# Cottam Solar Project

## ~~Draft~~ Statement of Common Ground with Scunthorpe & Gainsborough Water Management Board

Document reference: ~~EX4~~EX5/C8.3.15\_A

Figure 8.16.1: Landscape and Ecology Mitigation and Enhancement Plan – Cottam 1 North (Sheet 1) Revision A

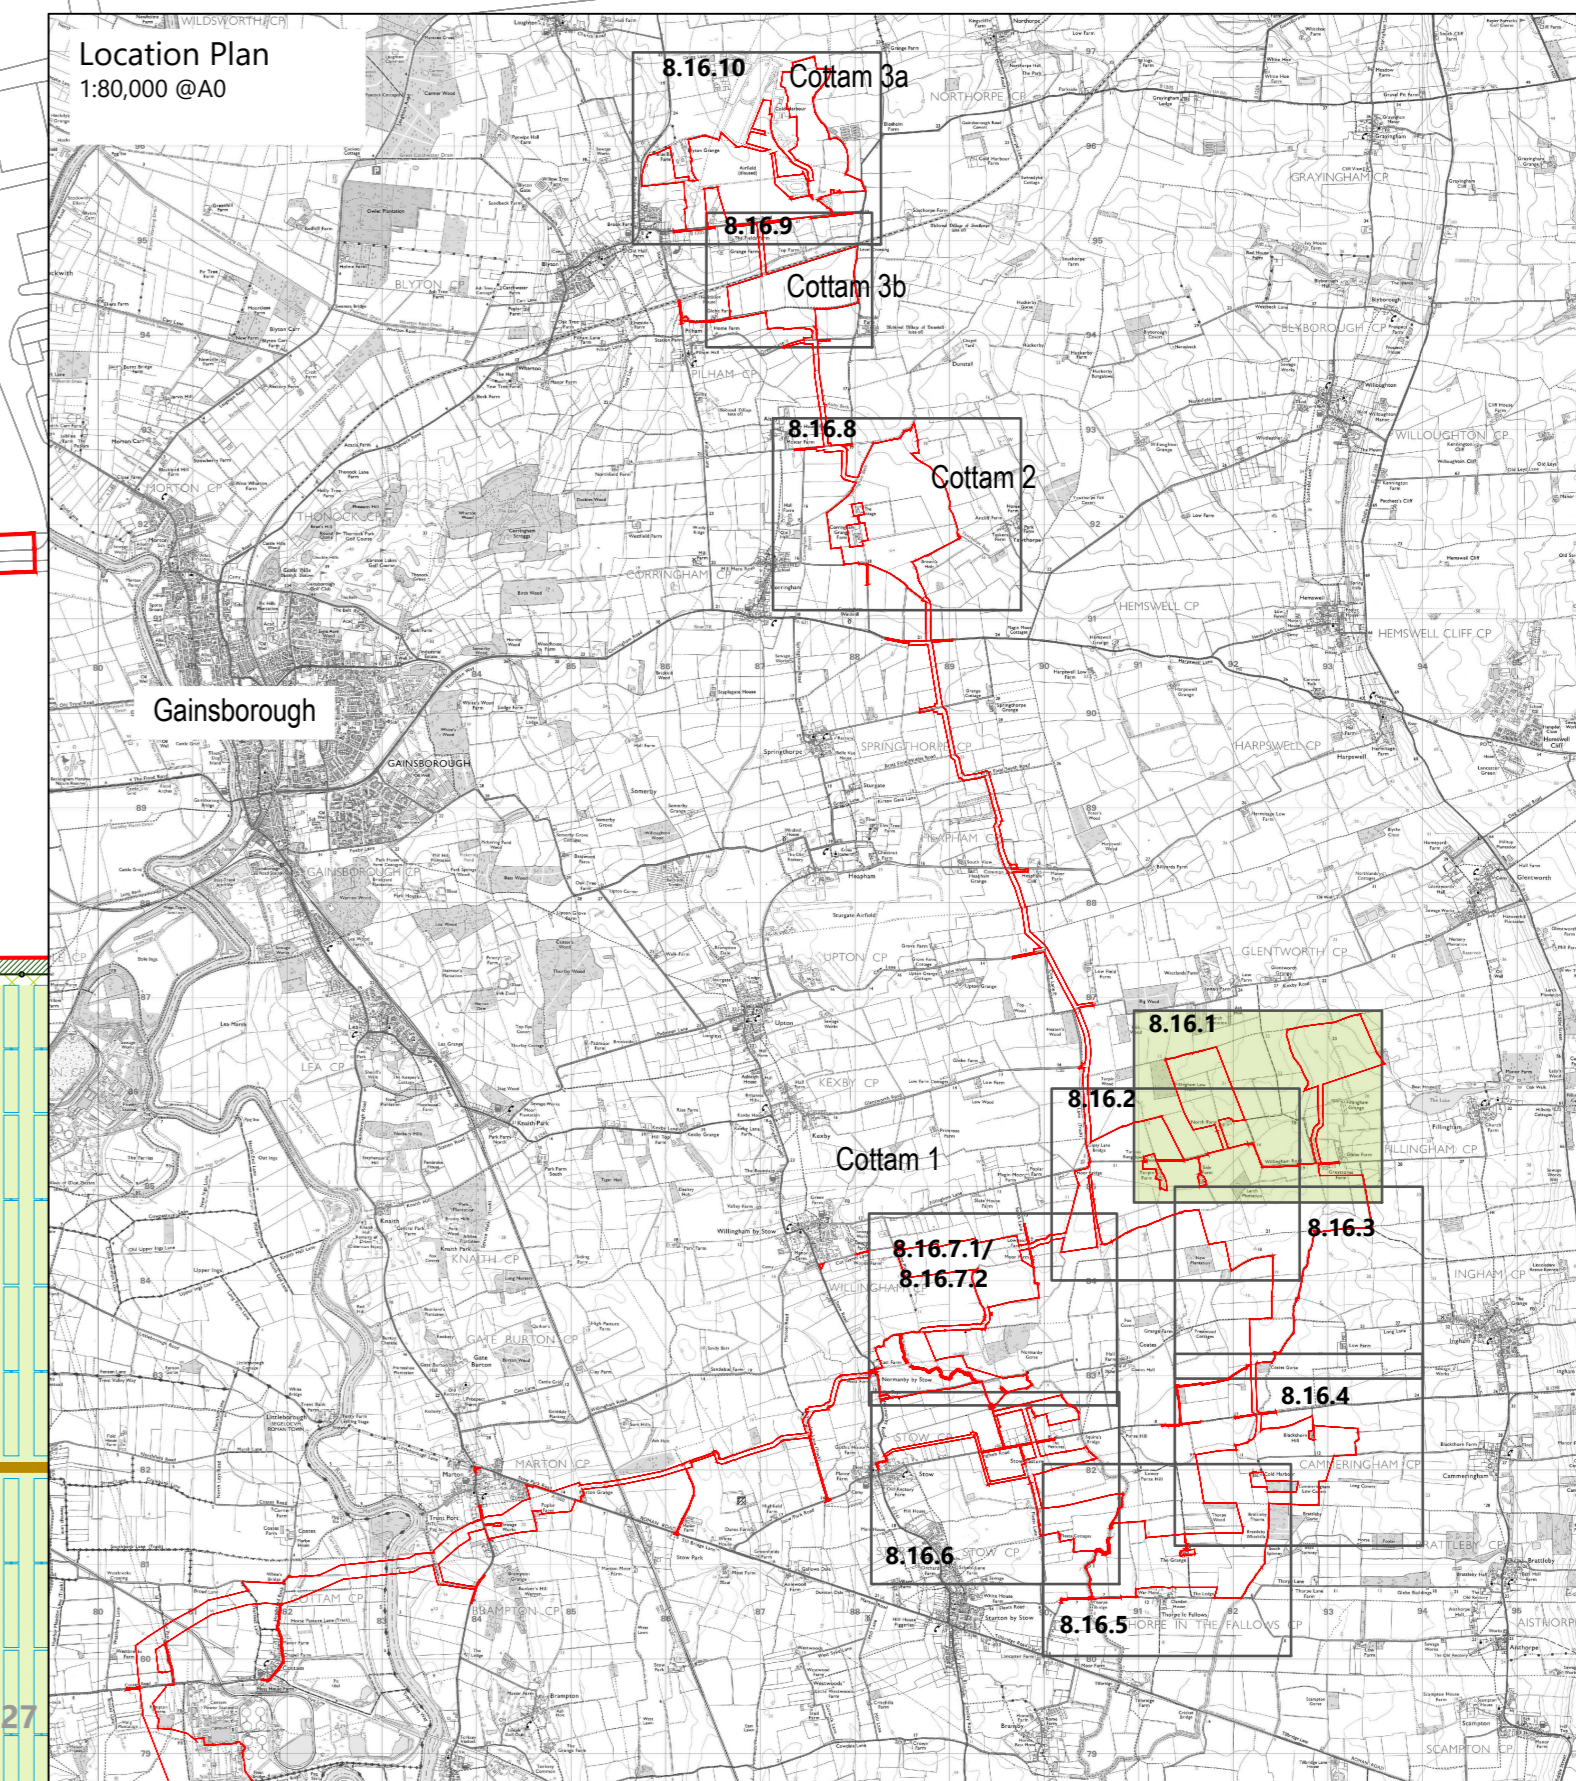
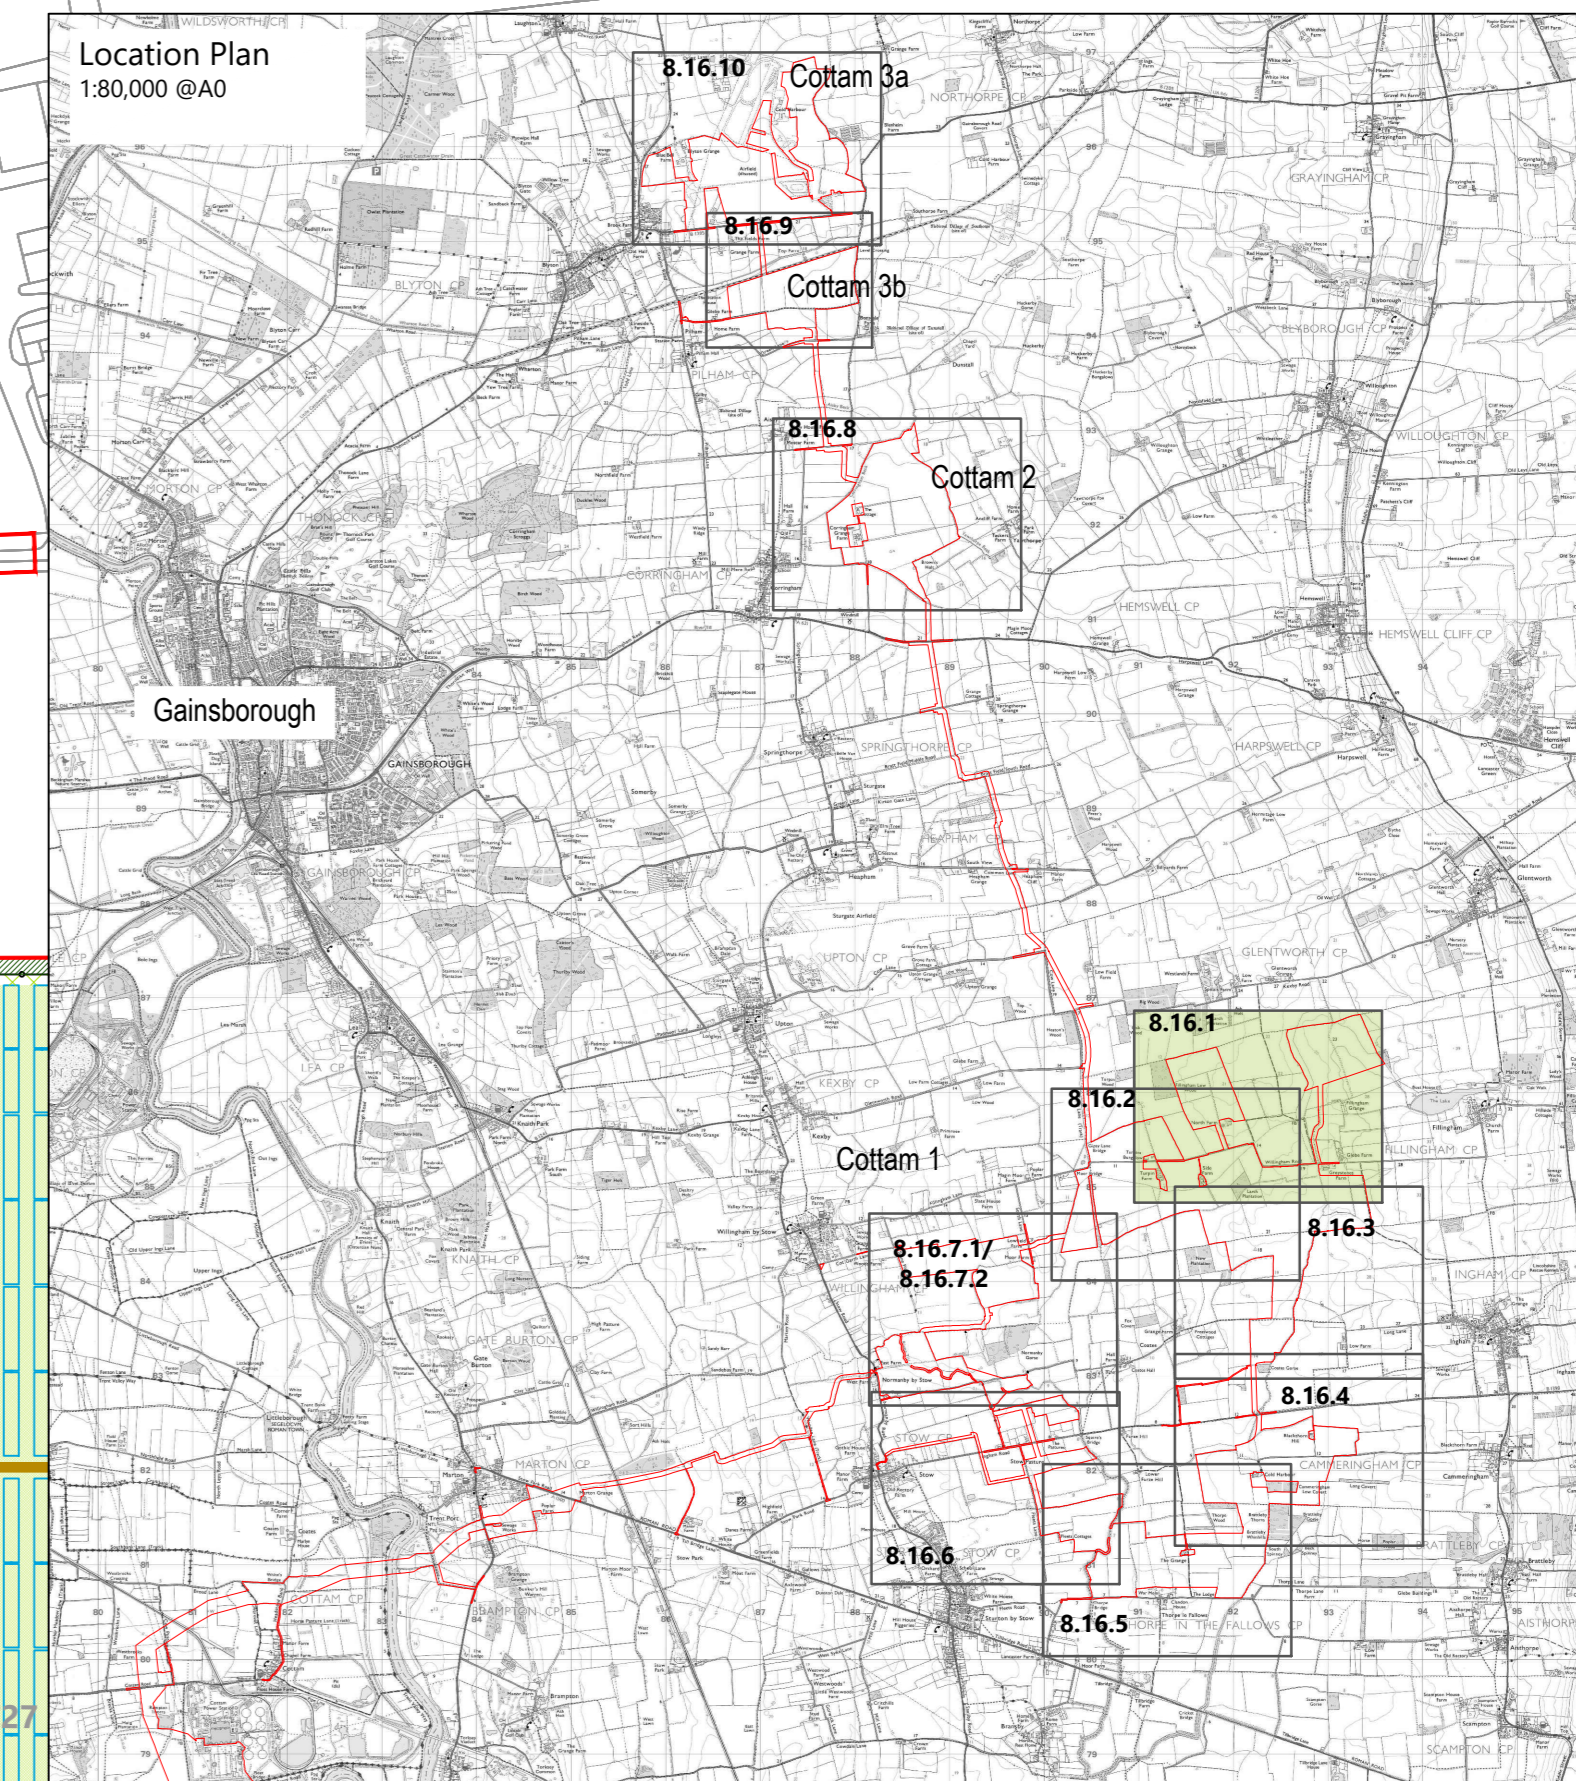
Main Topic Ref	Sub-topic	Stakeholder Comments	Applicant Response
Hydrology HY-01	Maintenance Access Strip and Embedded Mitigation	<p><i>From Relevant Representations – RR-045</i></p> <p><i>Fencing, planting and solar panels are shown on the submitted documents within the maintenance access strip adjacent to a number of Board maintained watercourses preventing or obstructing access. All fencing, planting and solar panels need to be relocated 9m from the top of the bank as agreed following the initial consultation with the Board Environmental Statement Chapter 10: Hydrology, Flood Risk and Drainage Table 10.1: Consultation.</i></p> <p><i>10.7 Embedded Mitigation. This states ‘8m easements have been established around all watercourses, including Main Rivers and Ordinary Watercourses and 9m from IDB assets’. However, the submitted plans show encroachment of fencing/planting/solar panels within the 9m distance to IDB watercourses which is unacceptable. Note the 9m is ‘from the top of the bank’ it is required to allow access for large plant to undertake maintenance.</i></p>	<p>The Applicant has discussed this matter with the IDB and both parties are in agreement that the scale of the project makes it impossible to provide the full details of the scheme at this stage. The Upper Witham IDB and S&amp;GWMB requirement of a 9m (from the bank top) clear strip adjacent to all the maintained watercourses is not fully defined on the current drawings. However, the Applicant can confirm that distances between IDB drains and proposed development/landscape mitigation will all be offset at a distance of at least 9m. Detailed drawings showing the required offsets will be provided to the IDB at the detailed design stage post DCO consent.</p> <p>Protective provisions for the benefit of the IDB are included in part 8 to Schedule 16 of the draft DCO [AS-012] which require that the IDB be consulted and approve any “specified</p>

### Figure 8.16.2: Landscape and Ecology Mitigation and Enhancement Plan – Cottam 1 North (Sheet 2) Revision A

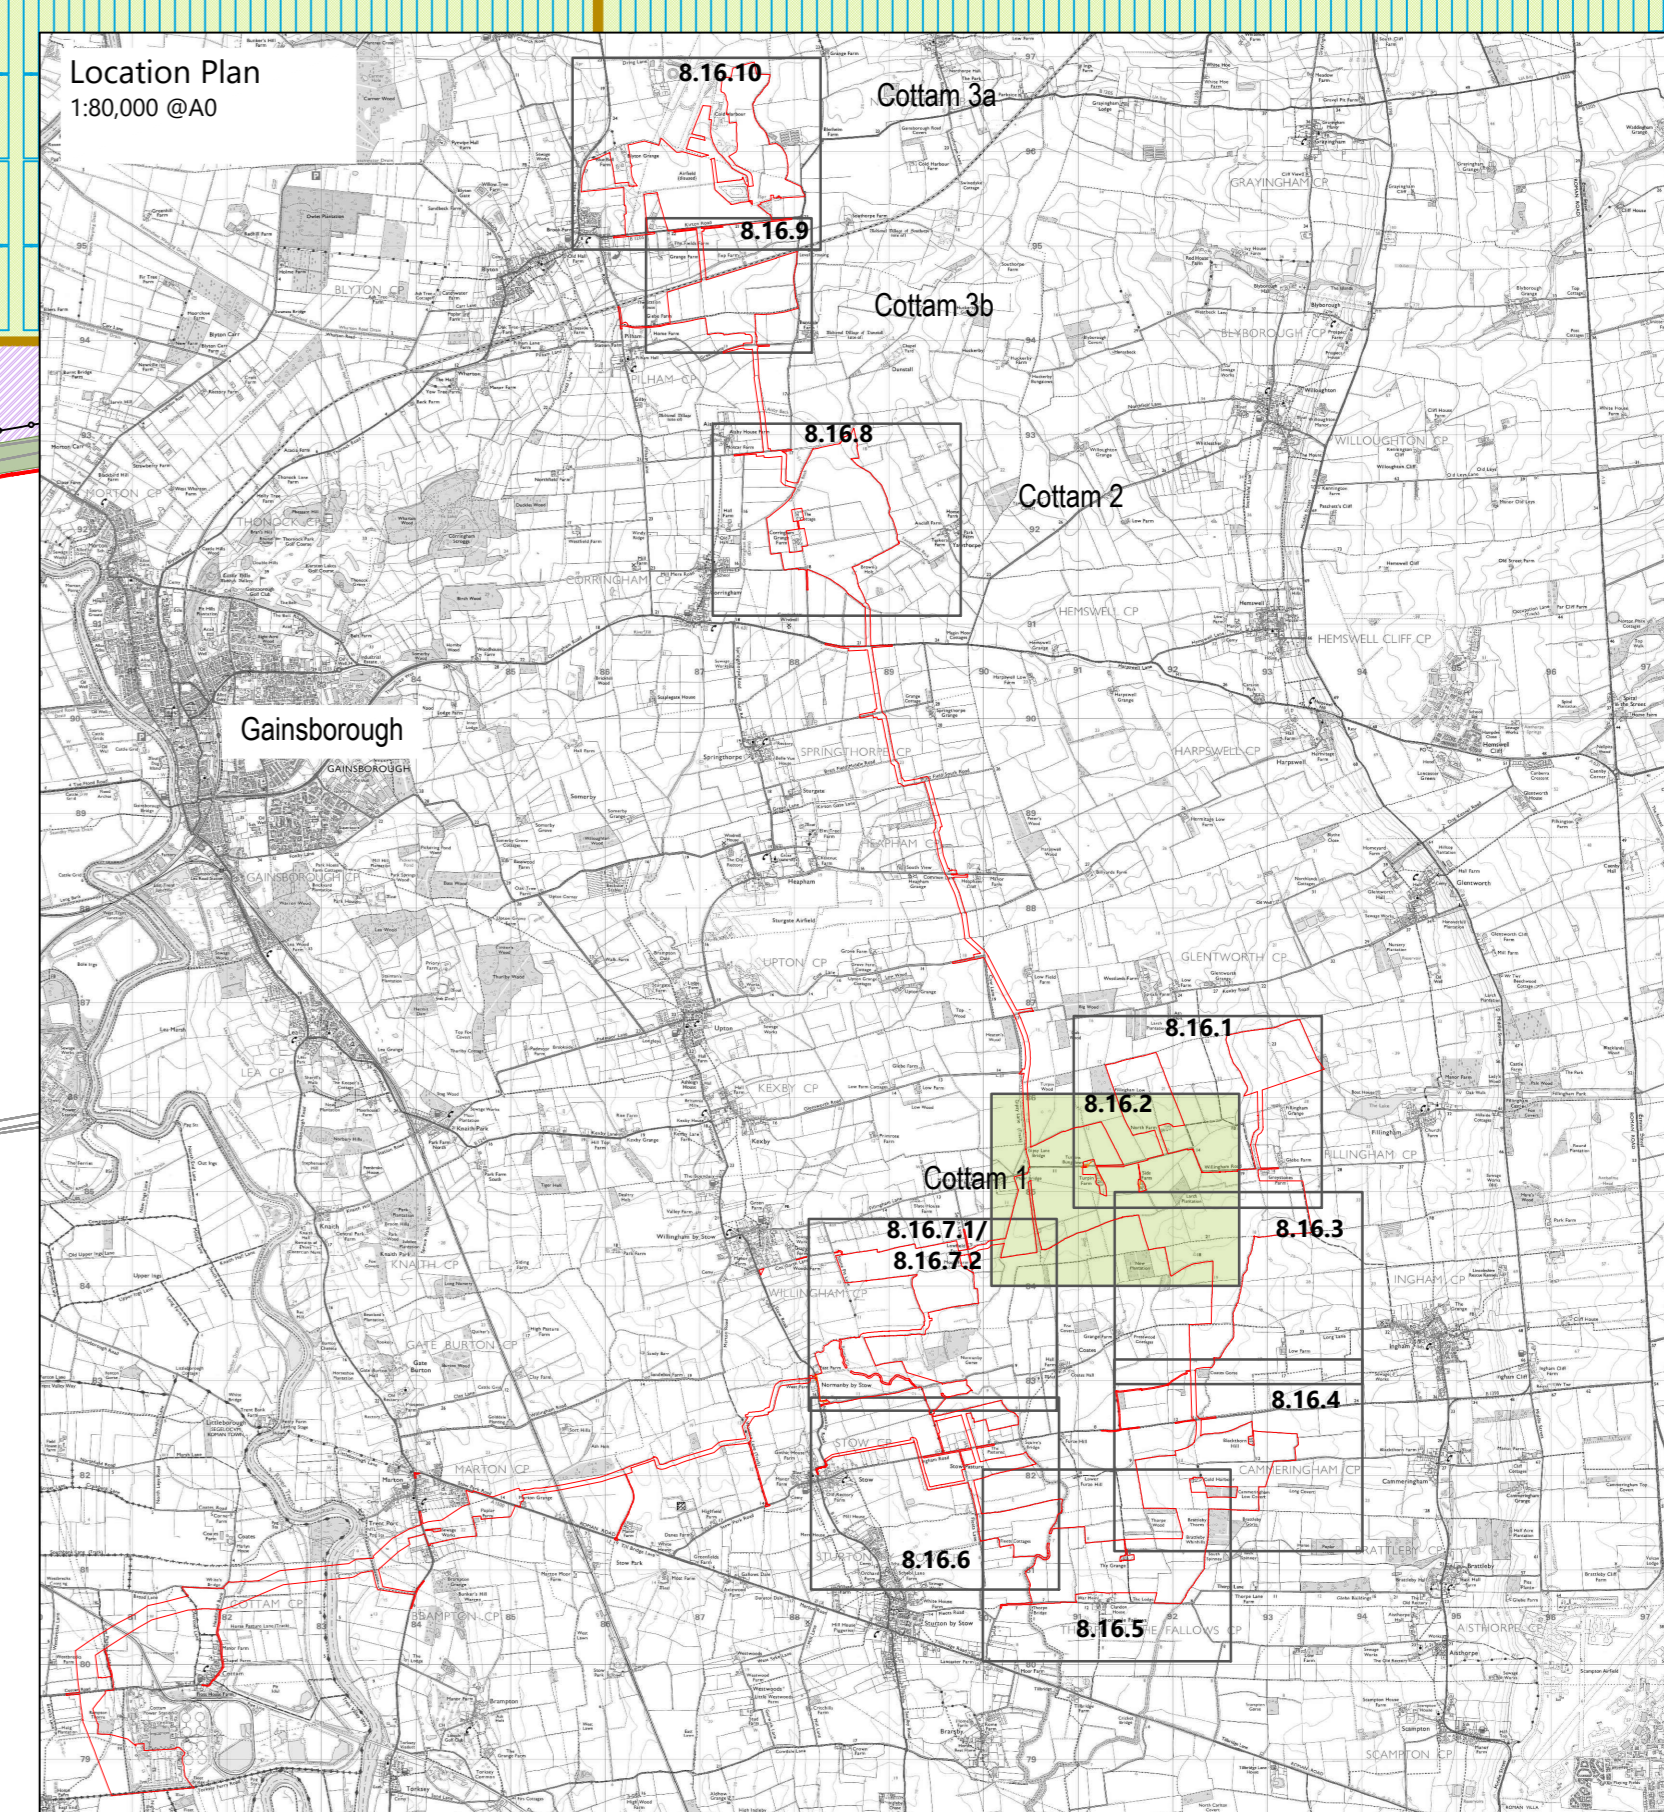
works" within 9m of any of the IDB's drains/watercourses.  Please also see the response to HY-03 below.
Hydrology <u>HY-02</u>	Identification of Watercourses	<p><i>"Figure 8.16.2: IDB watercourses not clearly identified."</i></p> <p>S&amp;GWMB have identified assets which may be impacted by the proposed scheme.</p> <p><u><i>S&amp;GWMB maintained watercourses</i></u></p> <p><i>Work Plan 2 (P2981_LPR_ZZ_ON_DR_Z_0064)</i></p> <p>Work Package 6A may impact on the 9m easement on both sides of Aisby Beck</p> <p><i>Work Plan 3 (P2981_LPR_ZZ_ON_DR_Z_0064)</i></p> <p><i>Work Package 1B may impact on the 9m easement on Corringham Beck, Yawthorpe Beck and River Eau ordinary watercourse (upstream of main river).</i></p>	<p>These IDB watercourses and drains have been considered throughout the layouts with a 9m offset as has been possible and as shown on Landscape and Ecology Mitigation and Enhancement Plans (Figures 8.16.1 to 8.16.10) [APP-305 to APP-315]. The Applicant has discussed this matter with the IDB and both parties are in agreement that the scale of the Scheme makes it impossible to provide the full information regarding detailed design at this stage.</p> <p>The Applicant notes that the drawings are based on the currently available data and mapping and in some cases the 'top of bank' is not defined. It notes that further survey work will be required to establish the 'top of bank' which will in turn give the 9m offset and required clear working access. The IDB can provide a shape file to confirm the locations during the detailed design stage post DCO consent.</p> <p>The Applicant will then provide a specific plan to the IDB at the detailed design stage (post DCO consent) to give clear details of all 9m</p>
